Subject: Canal Mews Barnham - BN/66/19/PL Condition 12

I am satisfied that the pre-commencement requirement of Condition 12 has been met, with fencing correctly installed and located as per the approved Tree Retention and Protection Plan.

Drawing No. 02 - Tree Retention and Protection Plan
Land to the East of Barn Rise, Barnham

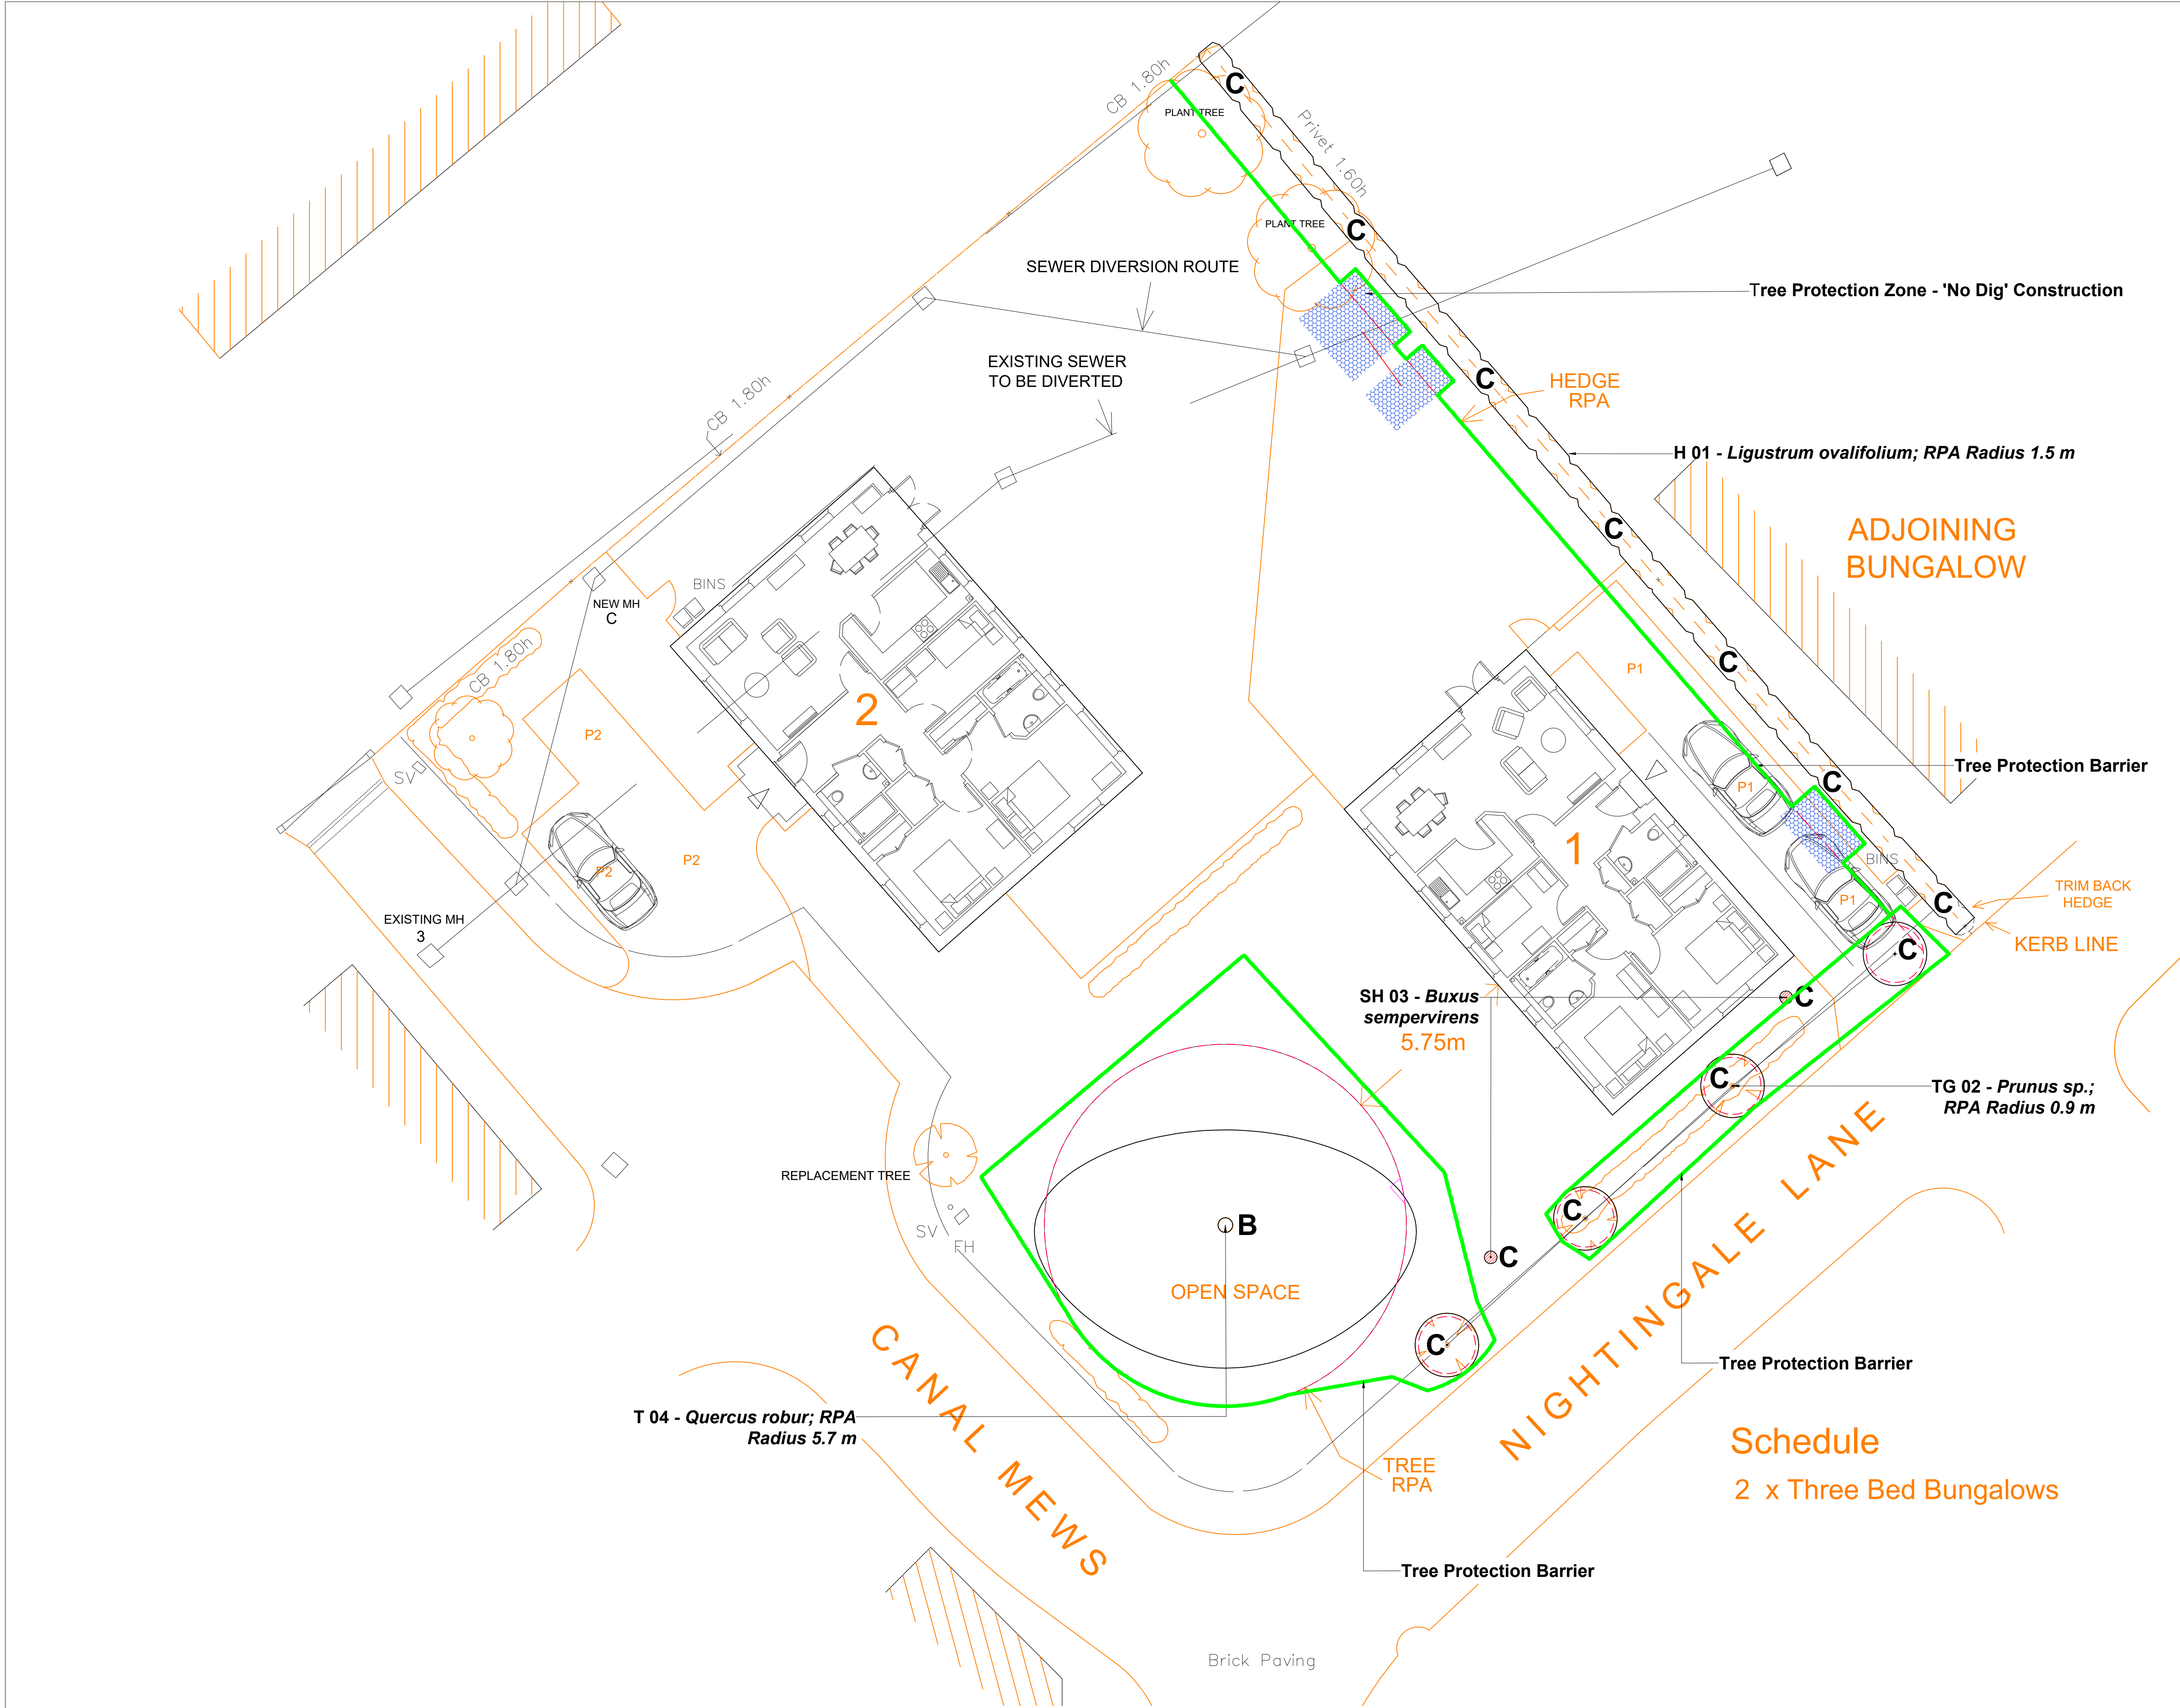
Please note that no building materials should be stored within a fenced-off area (Construction Exclusion Zone). I would be grateful if you could arrange prompt removal of the heavy bag shown in IMG_2054.jpg. Such materials may be harmful to the tree's root system by way of ground compaction and/or soil contamination. I refer to the approved Arboricultural Impact Assessment & Method Statement, LLD 1345-ARB-REF-001 (para. 5.1.)
